STATUTORY PLANNING CONSULTATION RESPONSE

Application Number:	3/2026/0400
Proposal:	Approval of details reserved by conditions 15 (surface water operation and maintenance); 16 (surface water verification report); and 17 (new build units verification) on planning permission 3/2022/0966.
Location:	Crow Trees Farm Crow Trees Brow Chatburn BB7 4AA

Lead Local Flood Authority Position

Client: Pringle Homes
Project: Crow Trees Farm, Chatburn
Drawing Title: Foul and Surface Water Drainage Plan

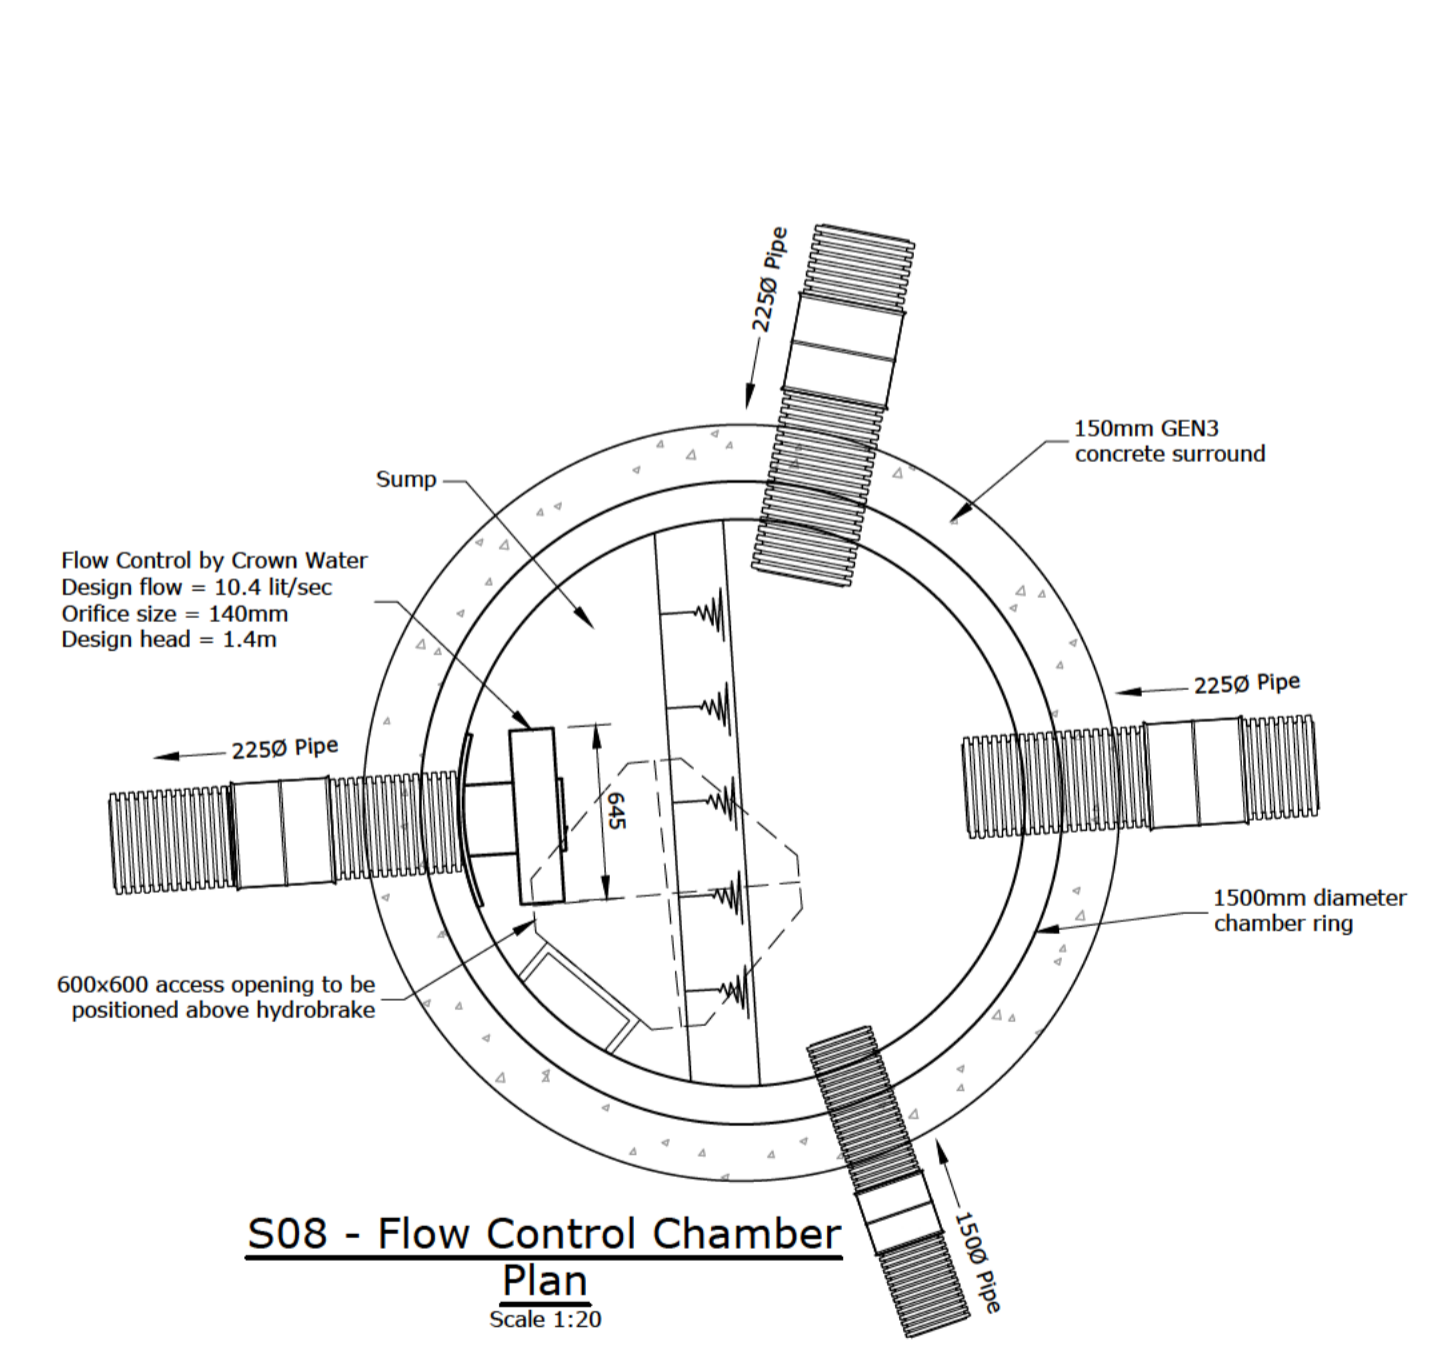
- The applicant has failed to provide clear and robust justification for the changes and the deviation in the proposed surface water sustainable drainage design, from the approved design (Foul and surface water drainage plan / K39346 – 20 / 21st March 2024 / RG Parkins) through the discharge of condition 13.

For the avoidance of doubt, the applicant has demonstrated that the development now discharges both foul and surface water into the same system before leaving the development, which is contrary to foul and surface water systems being drained through separate systems to their final discharge location, regardless of this final discharge location being a combined sewer. At this stage it is also unclear if the applicant has given due consideration to the implications of combining of these systems, as no non-return valve is evident to prevent foul water entering the surface water system in event of a blockage, surcharging or increased rainfall.

In addition to this, the applicant has provided evidence which demonstrates that the development may be discharging at a rate greater than the agreed greenfield rate, as there are both foul and surface water systems connecting into manhole C03 after the systems have been restricted by the necessary hydro brakes.

- The applicant has failed to provide evidence which accounts for the proposed deviation in design as outlined above, as this could have a direct impact on the management and maintenance of the surface water sustainable drainage system, in perpetuity.
